An
Bord
Pleanála

Inspector's Report ABP-306021-19

Strategic Housing Development

544 no dwellings, 2 no crèches, open space and associated works.

ATTENUATION TANK D
 SCALE 1:250

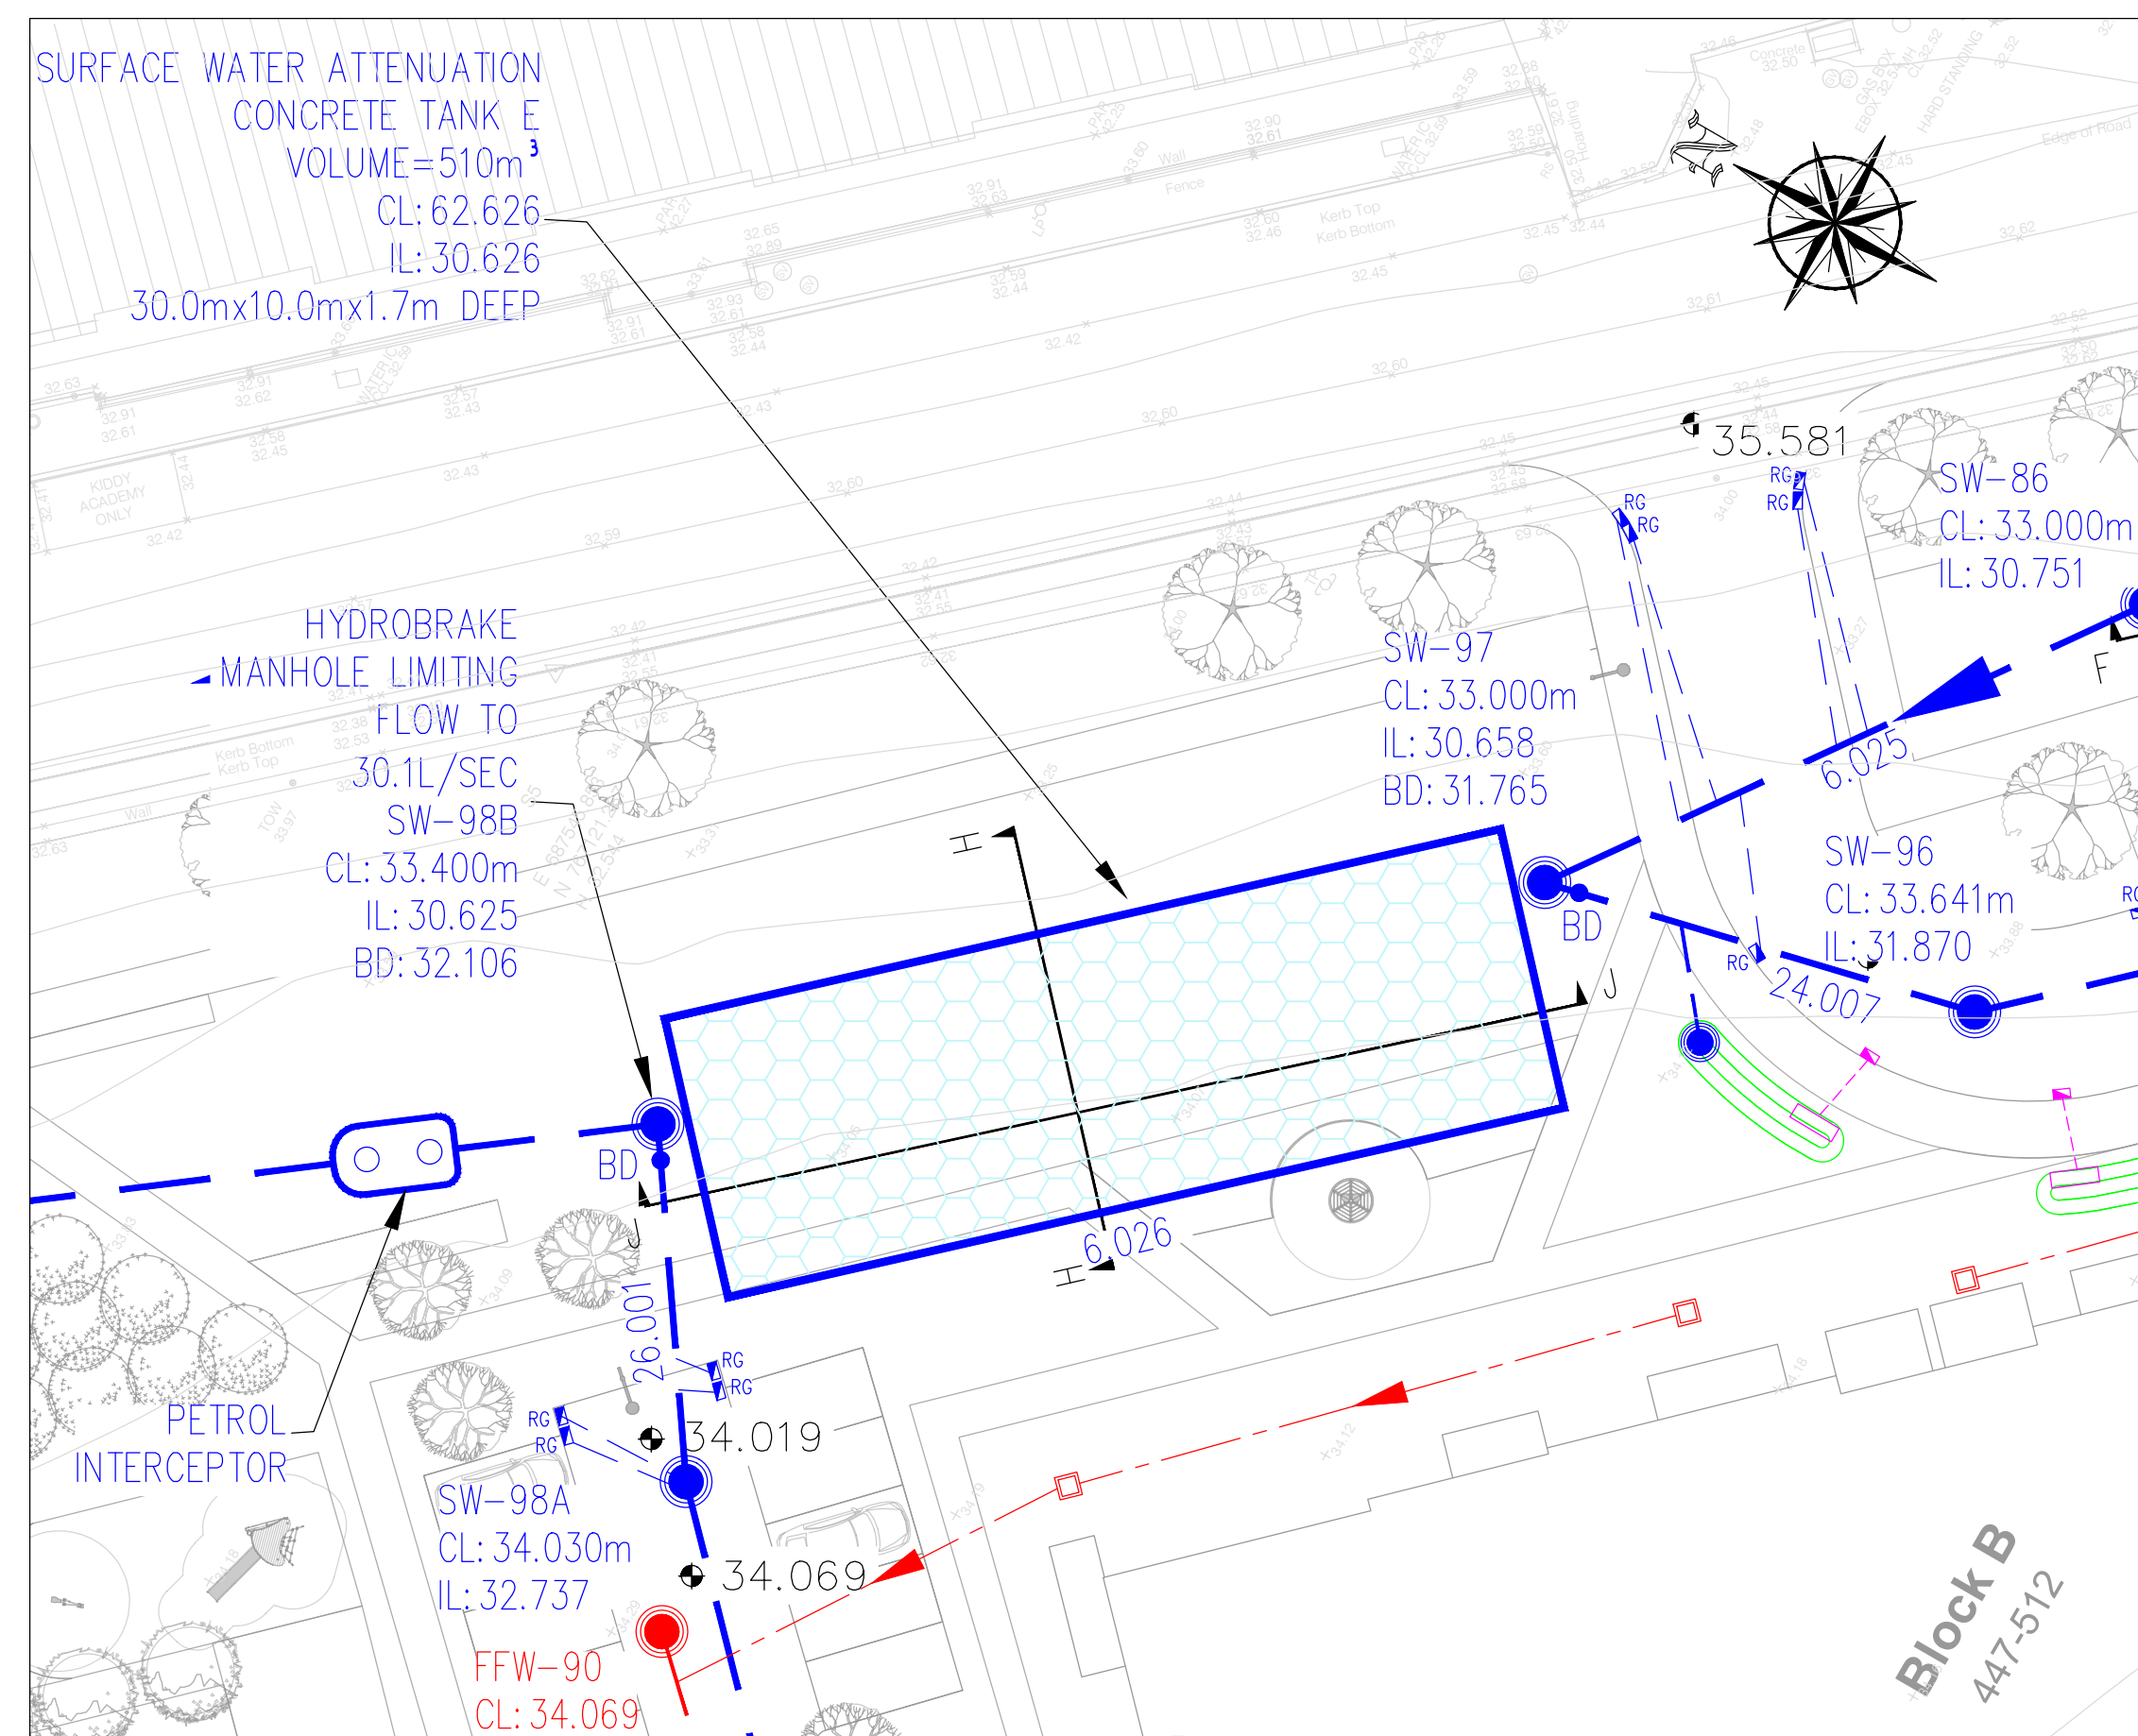
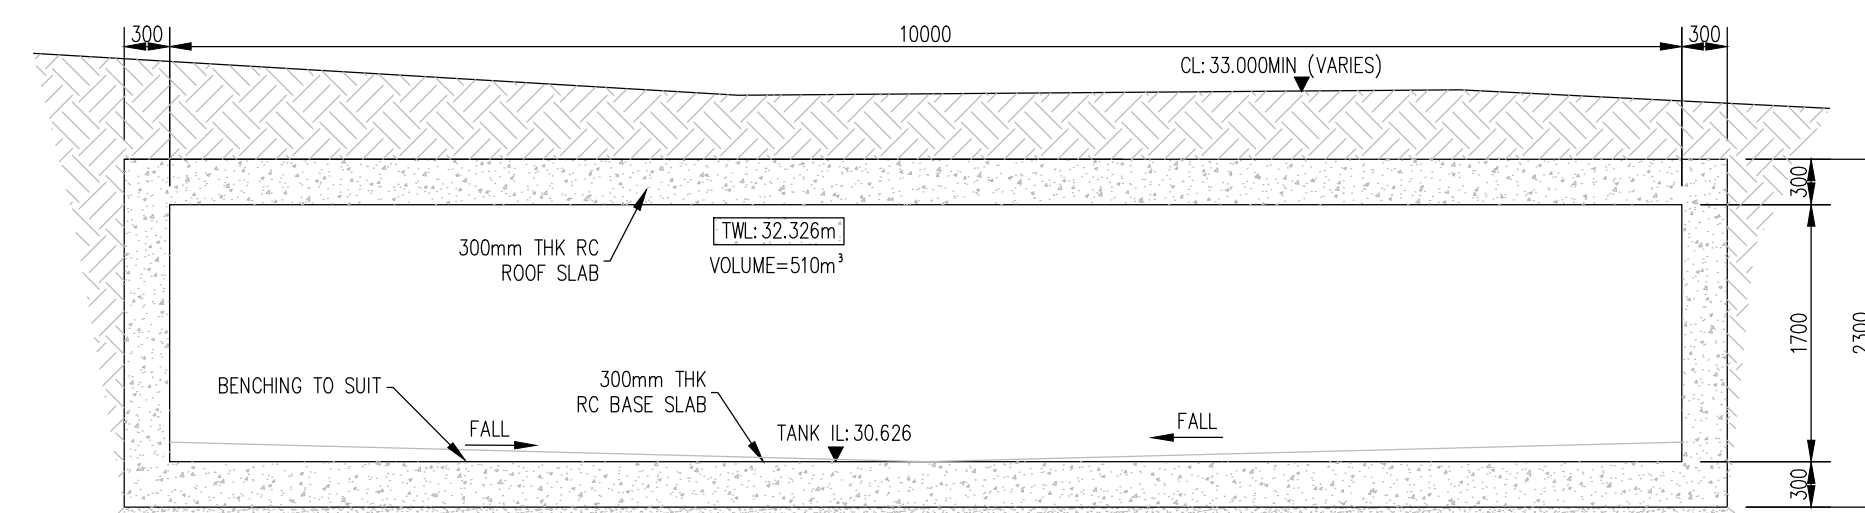
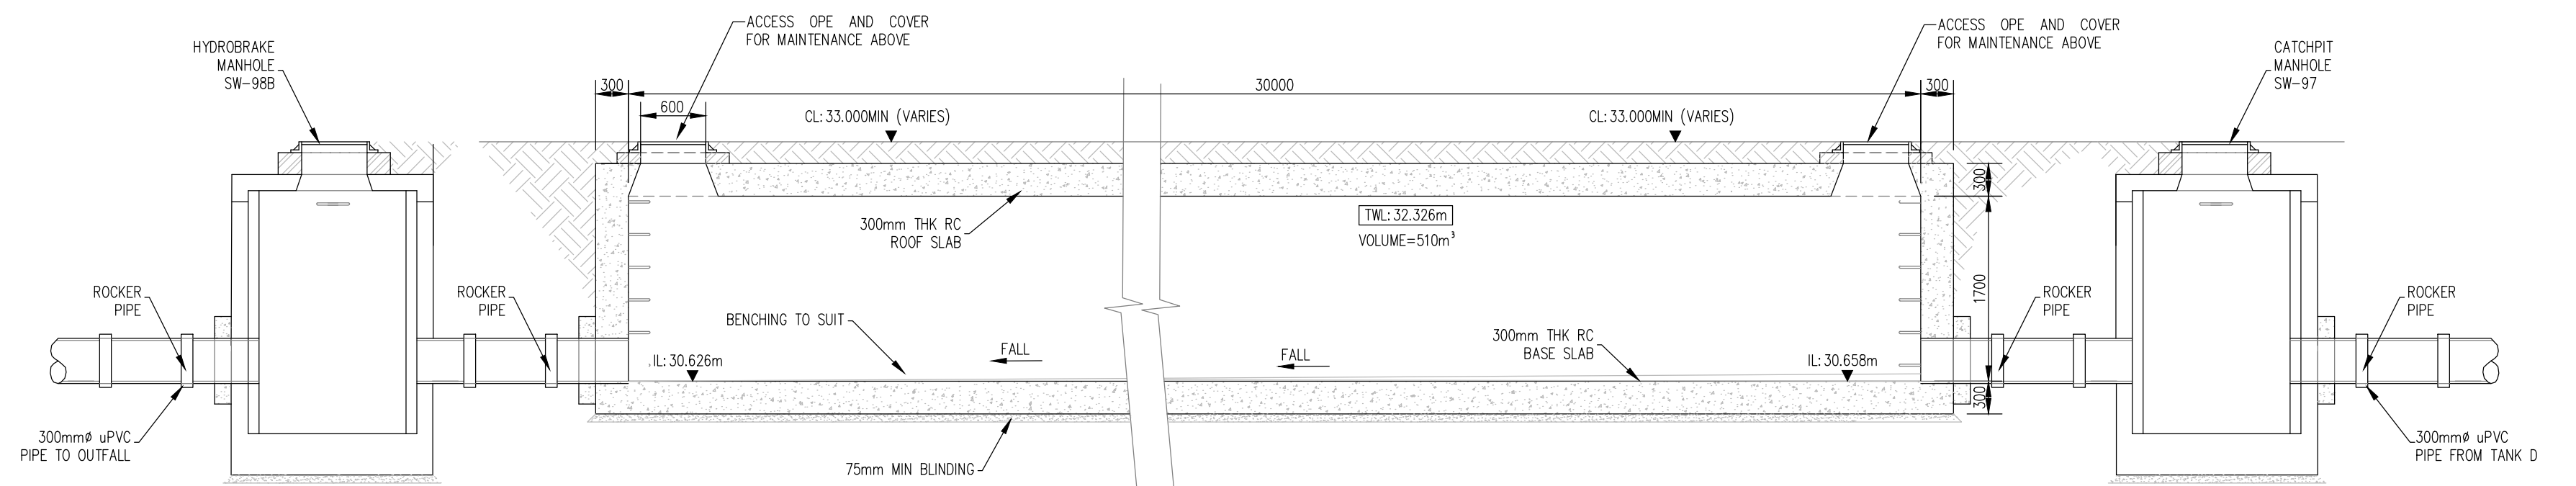
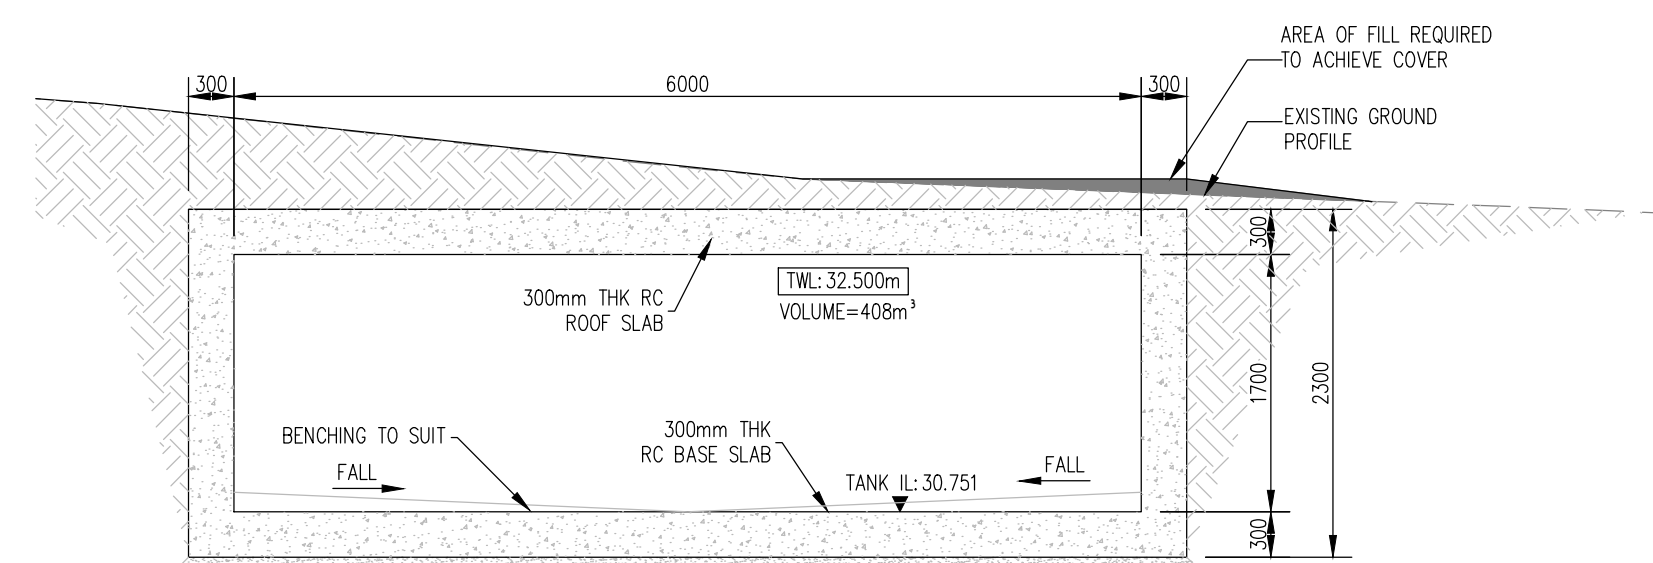
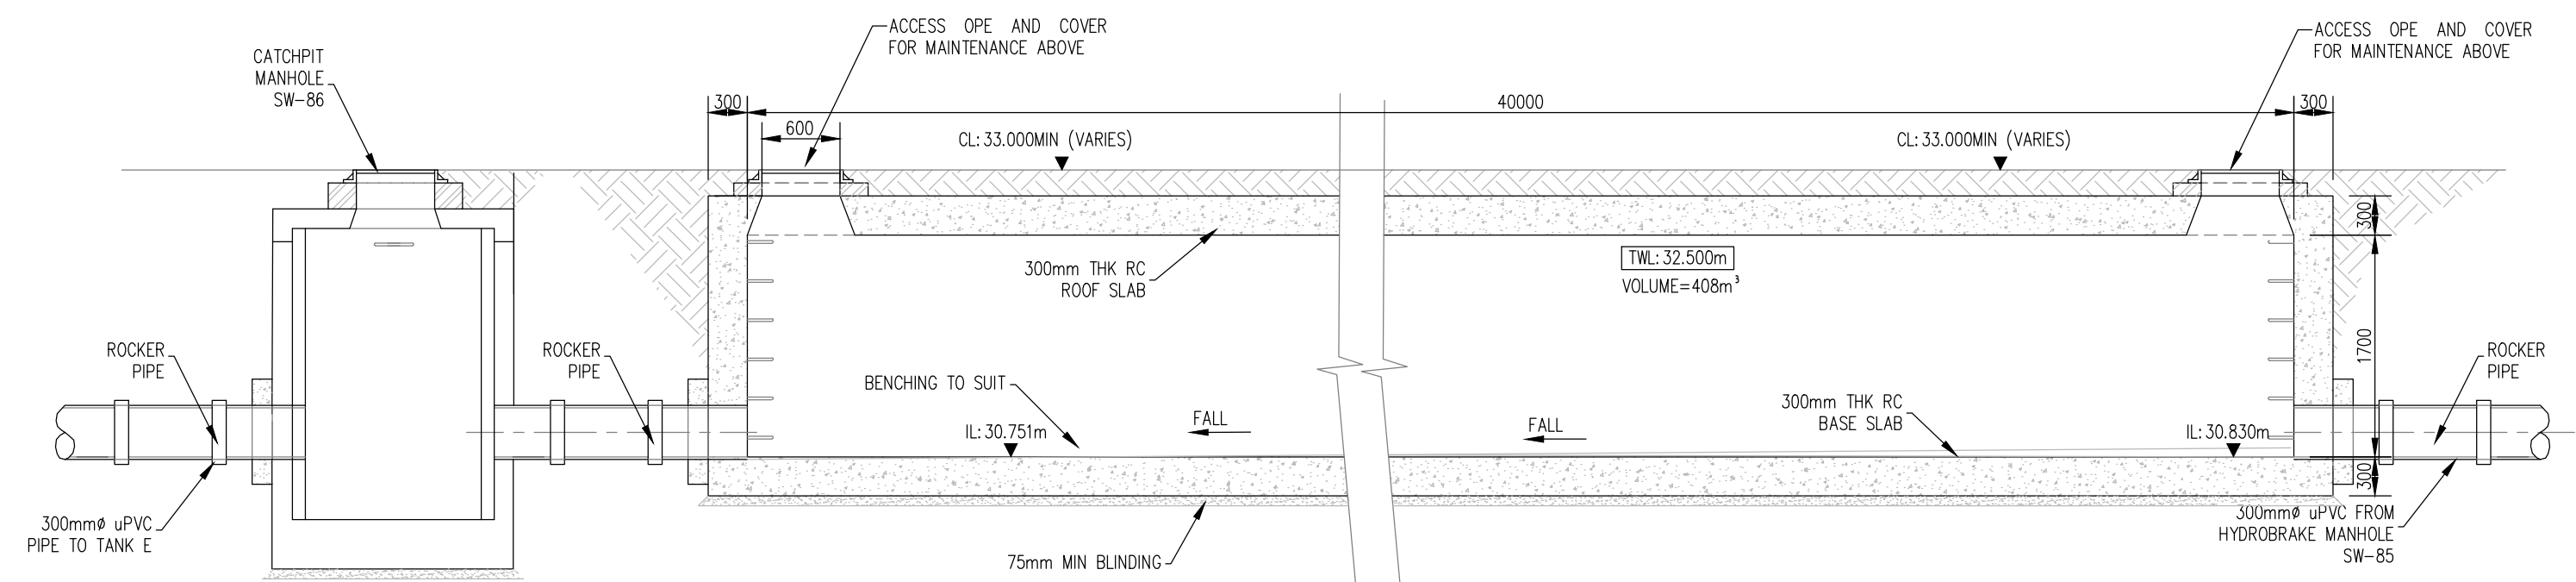
- Attenuation design should be amended to reduce the attenuation tanks and increase in SuDS.
- Integration of the existing surface water drainage system to the north of the site.
- Submission of a new surface water outfall and not use of the existing surface water connection.
- Each dwelling to have individual surface water connections to the public system.
